# London Luton Airport Expansion

## **8.26 Errata Report**

Application Document Ref: TR020001/APP/8.26

<b>Deadline:</b>	Deadline 1
<b>Planning Inspectorate Scheme Reference:</b>	TR020001
<b>Document Reference:</b>	TR020001/APP/8.26
<b>Author:</b>	Luton Rising

Drawing Title
Figure 20.1 Risk of Flooding from River and Sea (EA dataset)

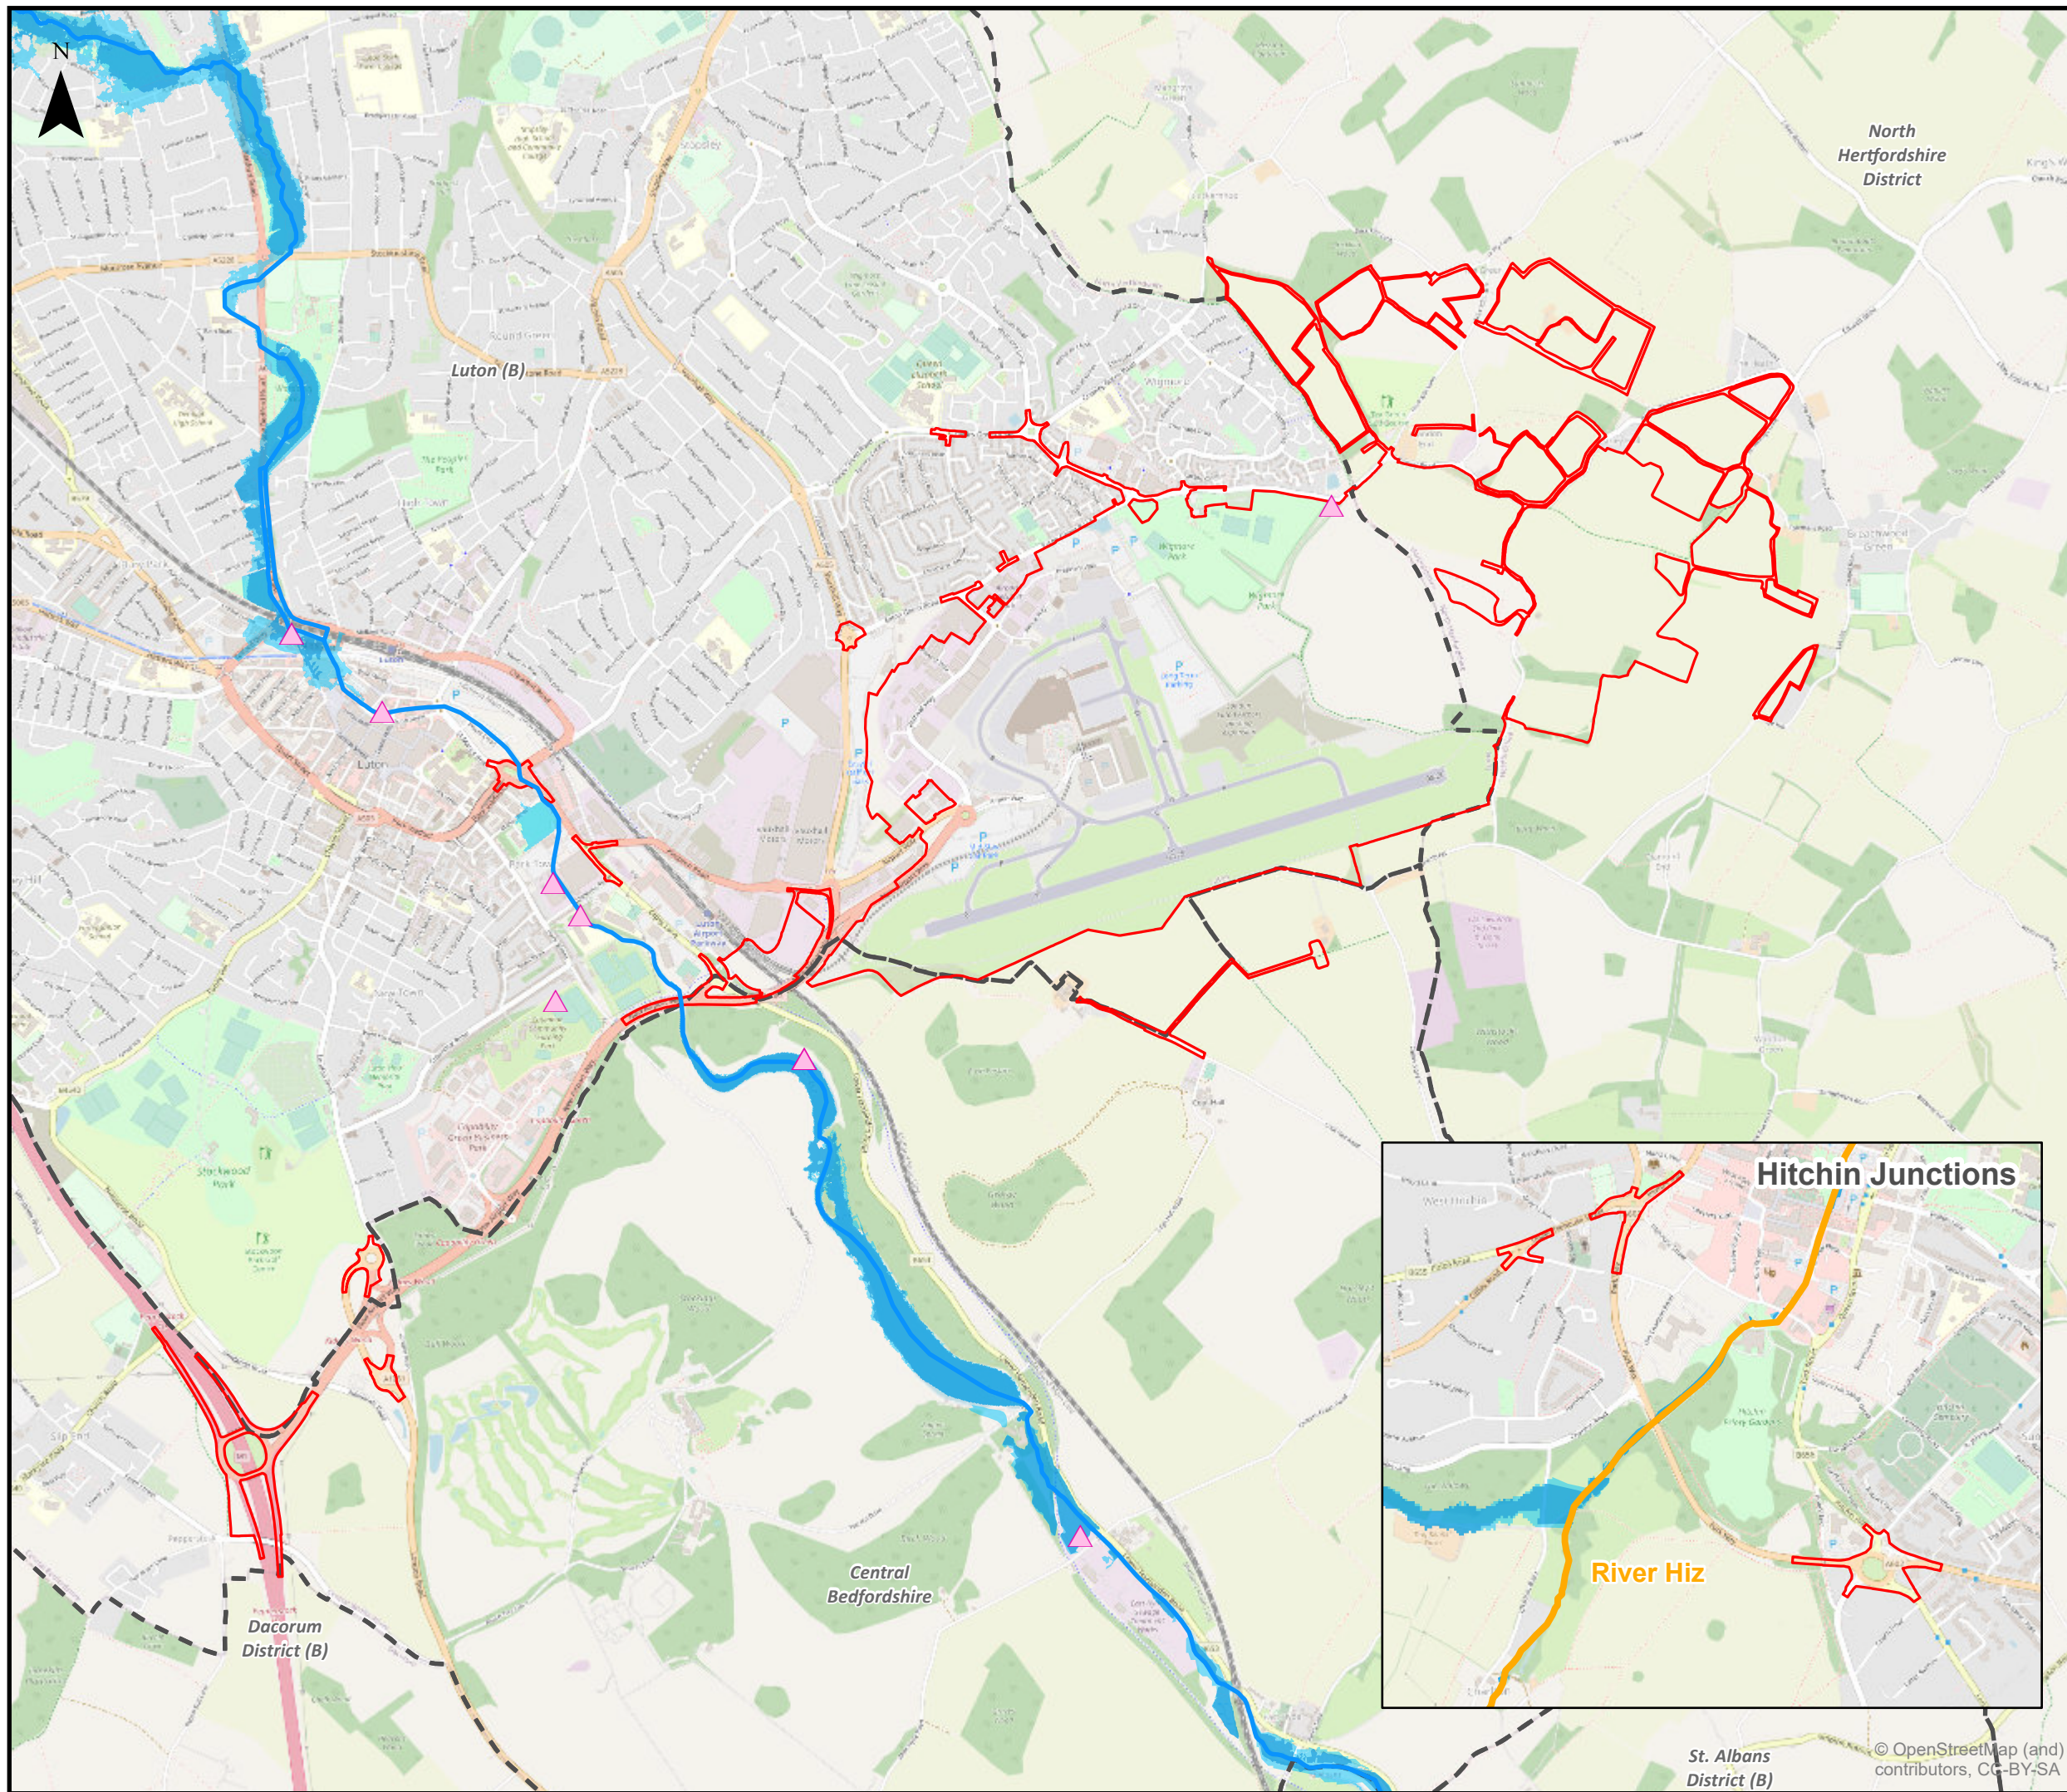
Application Document Reference	Section and Paragraph Reference	Errata	Amendment / Replacement Text
APP-219 7.08 Green Controlled Growth Framework Appendix A.	A4.13 Document Management Paragraph 13.2, page 19.	A typological error in the reference number.	Paragraph A4.13.2 should refer to clauses A4.13.3 to A54.13.7 (not 23.3 to 23.7), see below:  Level 2 and Mitigation Plan shall be publicly available on request unless clauses <del>23.3 to 23.7</del> <b>13.3 to 13.7</b> apply.
AS-082 5.02 Environmental Statement Appendix 4.1 Construction Method Statement and Programme Report.	2.5 Assessment Phase 2b (2.5.1, f. Landslide, vi.), page 8.	A typological error.	In section 2.5 Assessment Phase 2b, f. Landslide – a “Waste and Recycling Centre” is listed. Section to be removed as the separate recycling centre has been removed from scheme.  <del>vi. Waste &amp; recycling centre.</del>
AS-045 5.03 Environmental Statement Chapter 20 Water Resources	Figure 20.1, page 3	Figure error	Study area missing from Figure 20.1. Included in legend however missing from actual Figure.

AS-078 5.02 Environmental Statement Chapter 13 Health and Community	Table 13.6, page 27.	A typological error (deletion of row in table).	Table 13.6 Deletion of row below the heading ‘Wider Area’ (see below):  <del>‘Areas within which there are likely to be environmental impacts (e.g noise and visual impacts of the airport; construction and surface access traffic routes)’.</del>  Environmental impacts from the construction and operation of the airport are not relevant for the wider study area.
AS-078 5.02 Environmental Statement Chapter 13 Health and Community	Paragraph 13.9.3, page 64.	A typological error in paragraph.	There is a significant health effect <del>during all assessment phases</del> relating to the health determinant of ‘Perception and uncertainty’.
AS-045	Figure 20.1	Figure error	The 1km study area listed in legend as ‘Main Application Site 1k Buffer’ is not shown on map. The title of Figure 20.1 is Risk of Flooding from River and Sea

Application Document Reference	Section and Paragraph Reference	Errata	Amendment / Replacement Text
5.03 Environmental Statement Figures 20.1-20.7			(EA dataset), which is shown in the figure. Therefore, the 'Main Application Site 1k Buffer' in the legend can be ignored, or the reader can see the study area on Figure 20.2 if required. No amendment is proposed.
AS-077 5.01 Environmental Statement Chapter 10	Table 10.6, page 20	Typological error	Consultation meeting events with Historic England to align with the SoCG should read:  'Response to 2022 Statutory Consultation dated <del>04 April</del> 02 April 2022'
AS-077 5.01 Environmental Statement Chapter 10	Table 10.6	Event missing from the table	Consultation meeting events with Historic England described in Table 10.6 should include a further meeting that took place on 06/12/22 to align with the SoCG.
AS-125 7.04 Need Case	Section 6.6 Parameters for environmental assessment, surface access planning and capacity assessment, Paragraph 6.6.13, page 127	Typological error within paragraph	Paragraph 6.6.13 refers in error to Figure 6.8, it should read Figure 5.8.  'In addition to this upward shift in aircraft capacity, the main airlines operating at the airport have also been focusing on increasing the proportion of seats sold on each flight (the load factor) in recent years. These carriers historically targeted selling around 80-85% of all available seats, but recently have actively sought to increase this over 90%. This is illustrated in <del>Figure 6.8</del> Figure 5.8, illustrating the upward trend'.
